From: Sue Howell <Sue.Howell@arun.gov.uk>
Sent: 28 October 2021 11:53
To: Planning.Responses <Planning.Responses@arun.gov.uk>
Cc: Claire Potts <Claire.Potts@arun.gov.uk>
Subject: Planning Consultation on: AL/87/21/PL - revised comments

Response to Planning Application

Application ref: AL/87/21/PL

Location: Oldlands Farm Newlands Road Bognor Regis PO22 9FJ

client
project
Oldlands Farm,
Newlands Road,
Bognor Regis PO22 9FJ
title
Landscape Planting Plan
drawing number
05-991-701
scale
1:500 @ A0
date
1st June 2021
drawn
CJO
checked
RH
revision
-

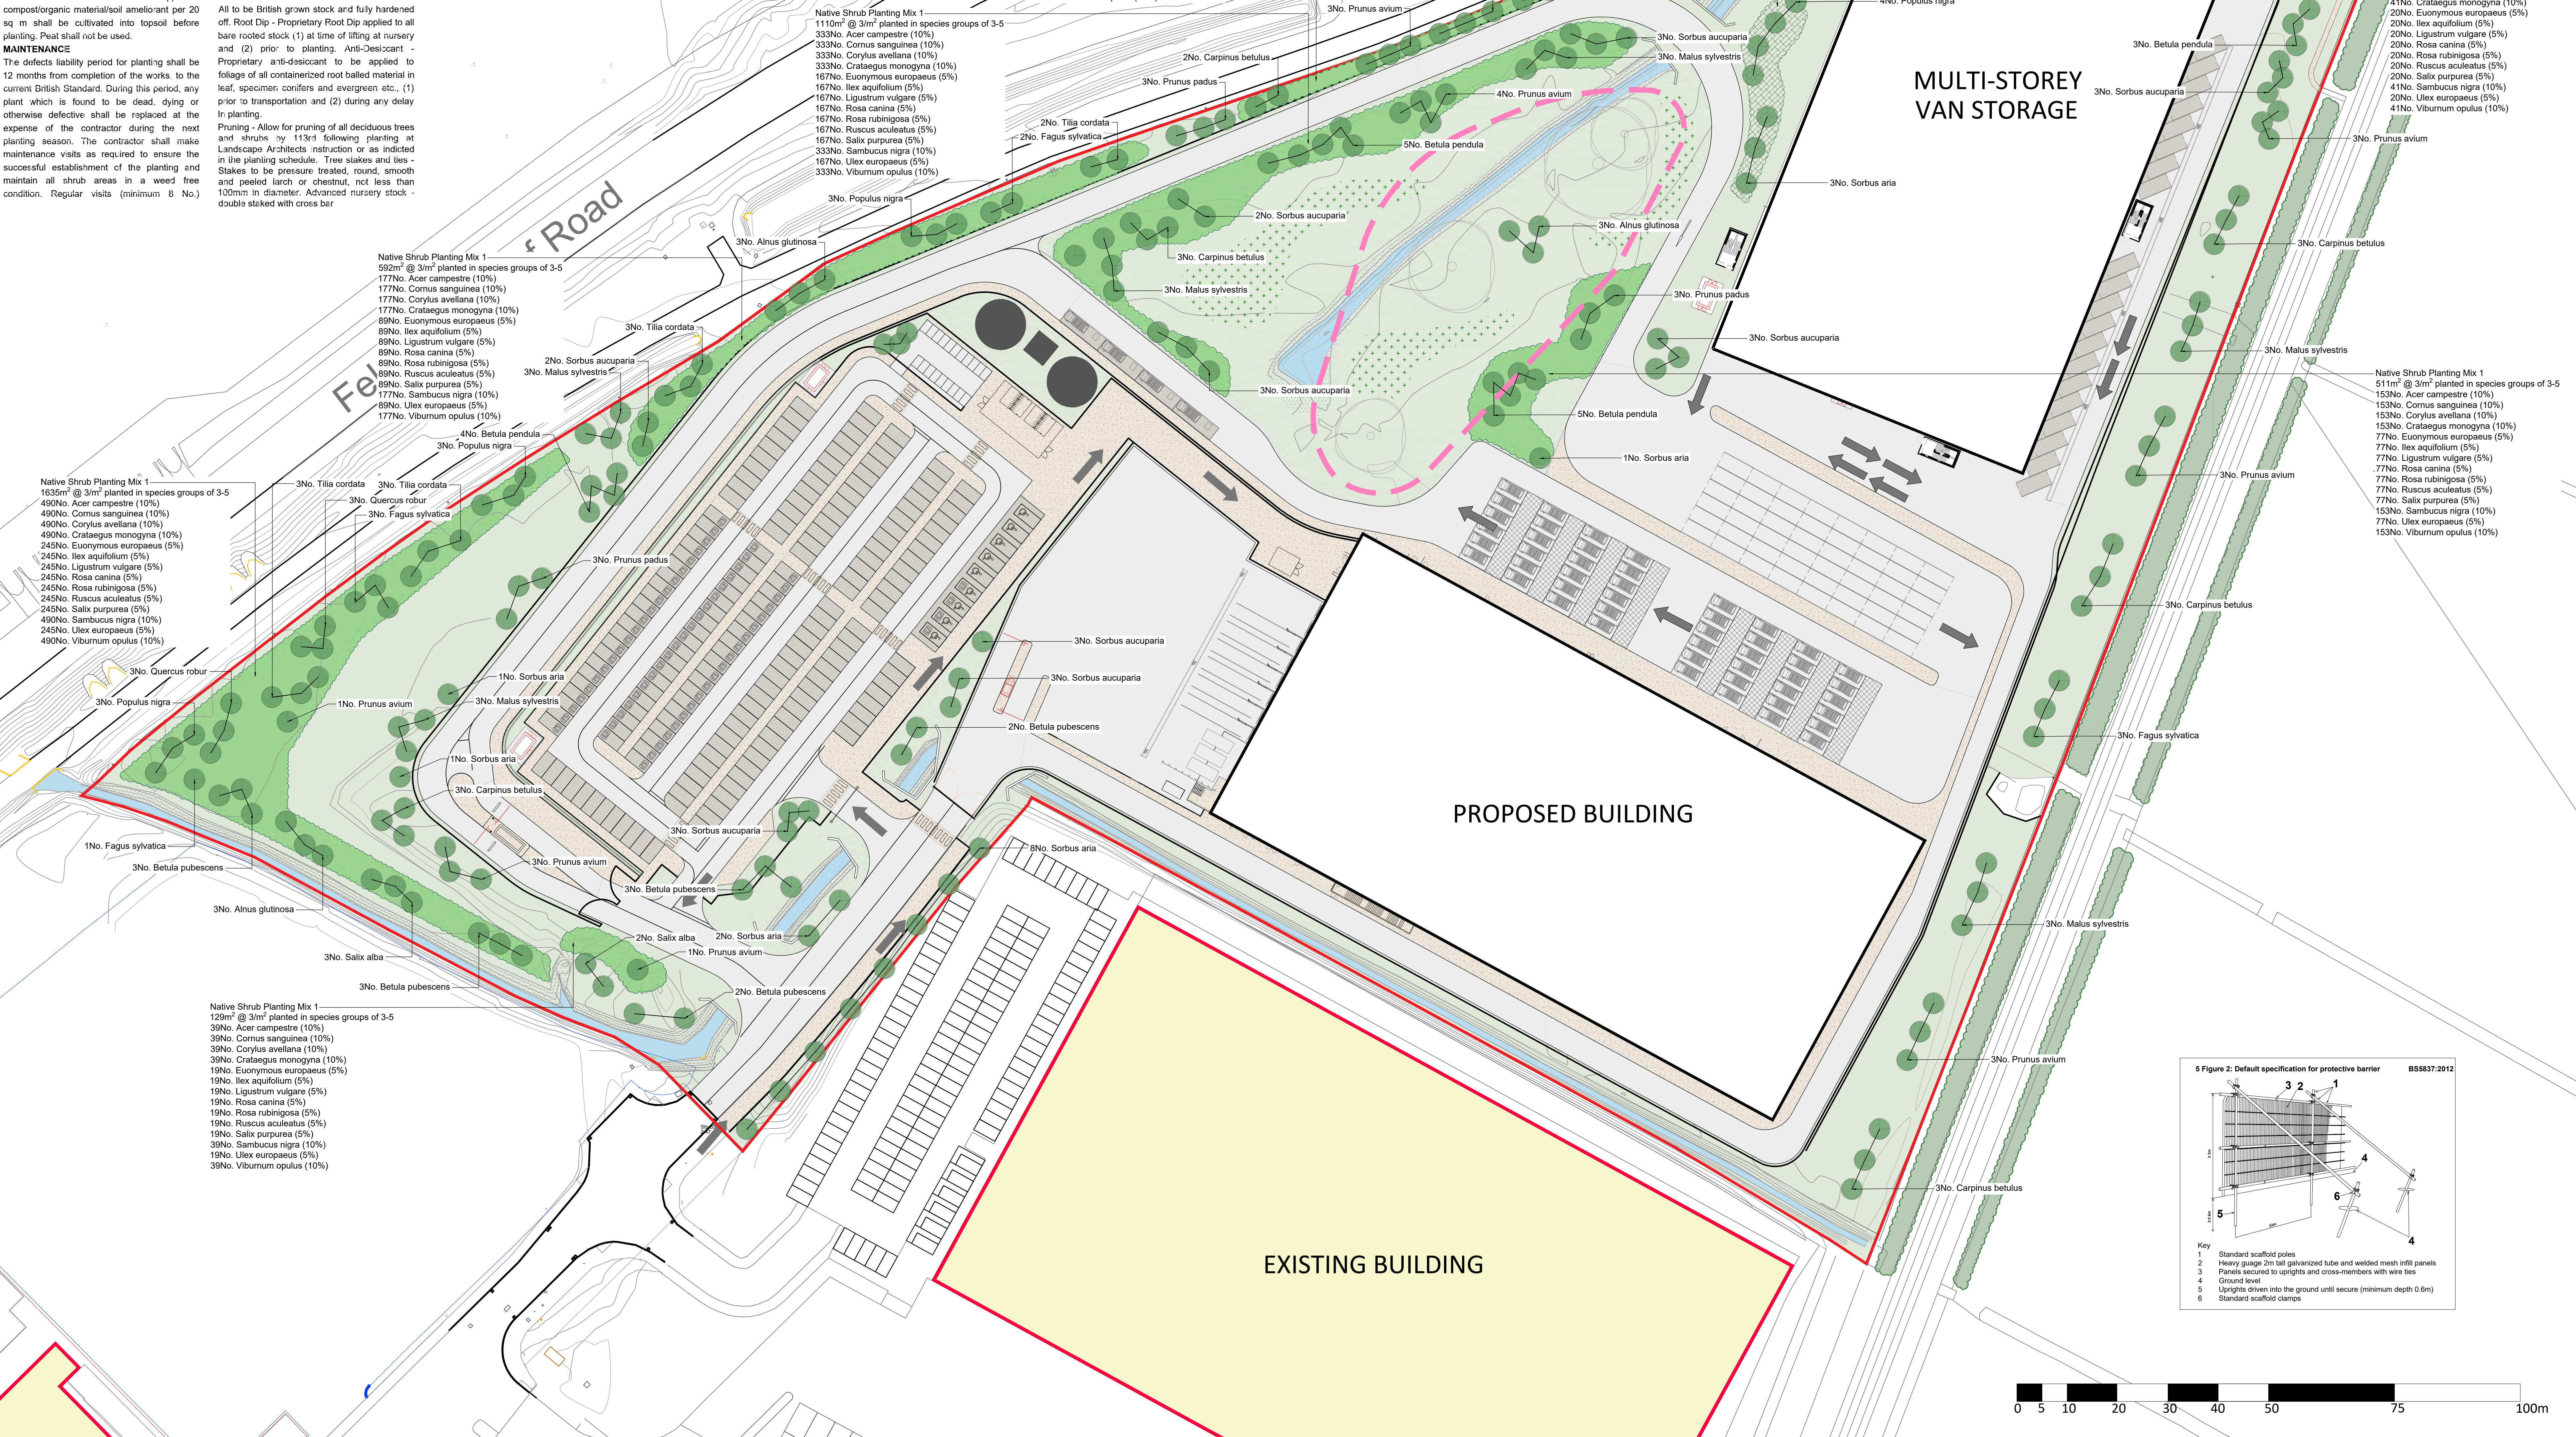
The NPPF para 124/127 relate to good design principles which equally apply to commercial development. The Landscape proposals in Landscape Planting Plan 05-991-701 and Landscape Strategy Plan 05-991-300-Rev A has proposed a scheme with suitable tree and shrub species for location and purpose. The mix indicated has provided good cover with predominantly native trees and shrubs to the periphery and building surrounds. Both the shrub/transplant Native shrub mix 1 and 2 have indicated planting at a good size at time of planting (Native mix 2 at a 1.6-1.8m size at time of planting) which is encouraging to see and will provide instant maturity to the scheme.

The landscape Planting Plan 05-991-701-REV E has been amended as requested for clarity this now shows as intended the tree stock indicated as 18-20cm girth is a nursery stock BS3936 Semi Mature Tree classification. Detail amended to show these trees (where 18-20 girth) as Semi Mature trees and not Select Standards as previous iteration.
